Application Ref: H09-0473-25

Proposal: **Demolition of existing derelict dwelling & erection of detached 3 bed self build dwelling**

Location: **The Poplars Chapel Drove, Holbeach Drove, Spalding PE12 0PT**

ADDITIONAL INFORMATION REQUIRED

block plan
1:500

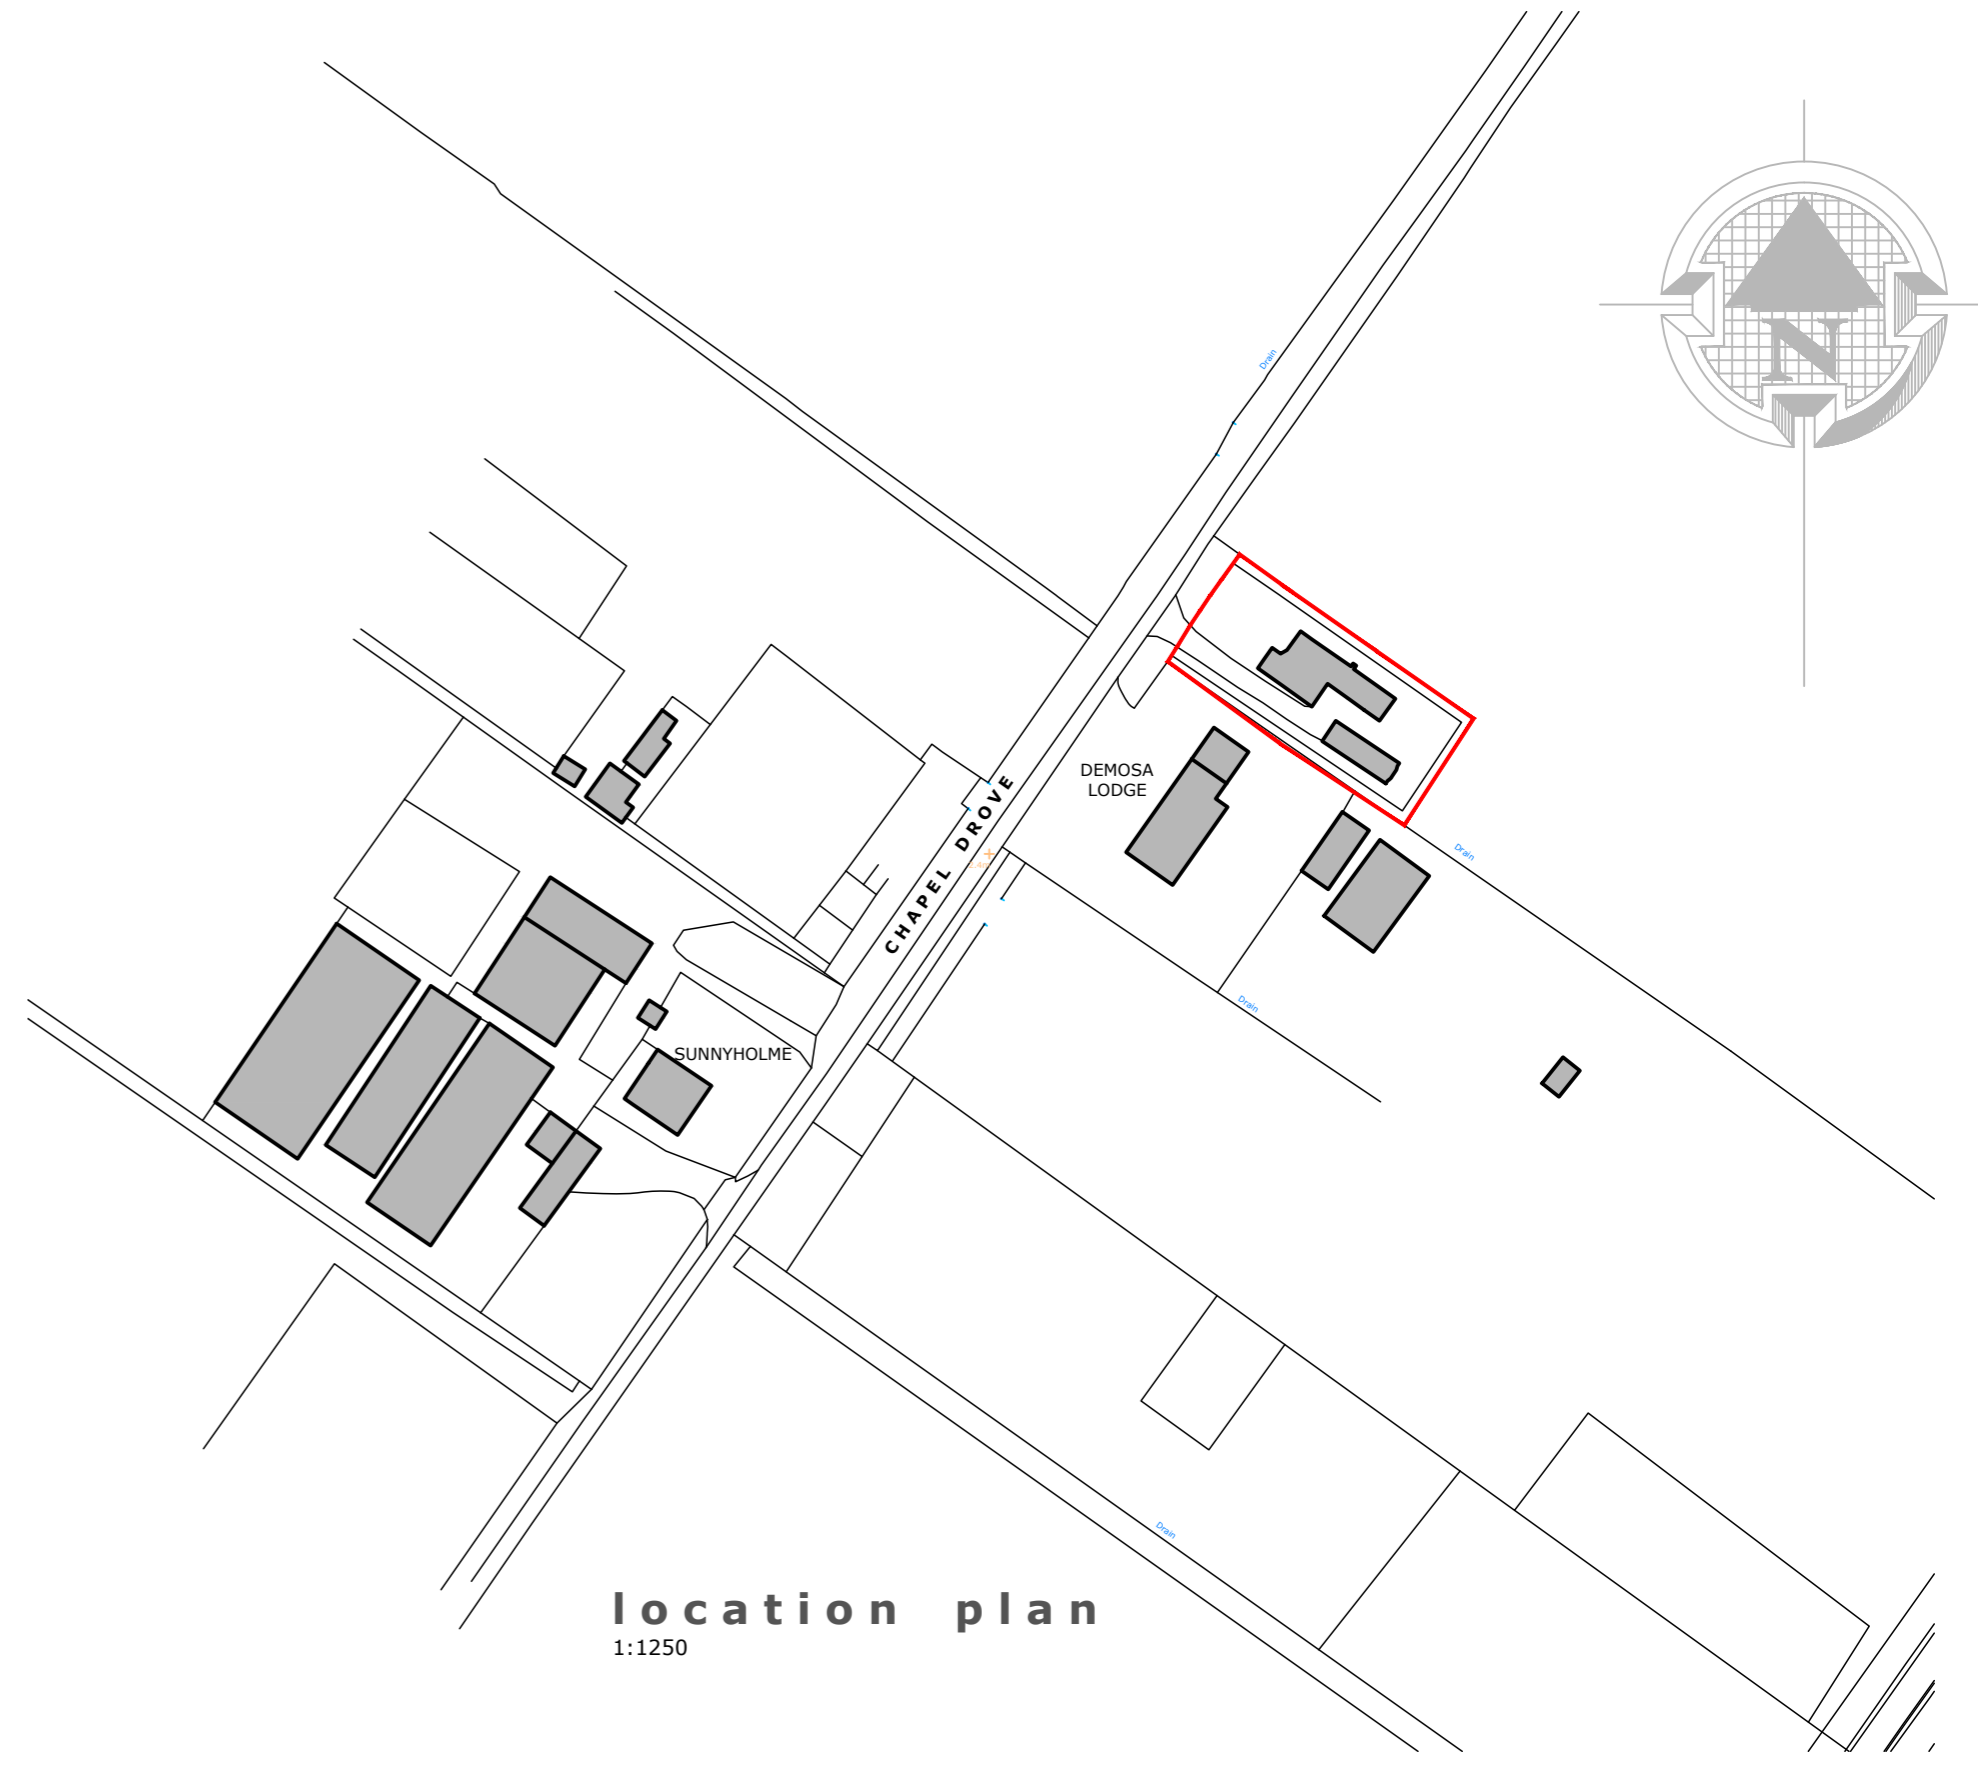
The access needs to be upgraded to Lincolnshire County Council Specification and a note should be added to the proposed site plan.
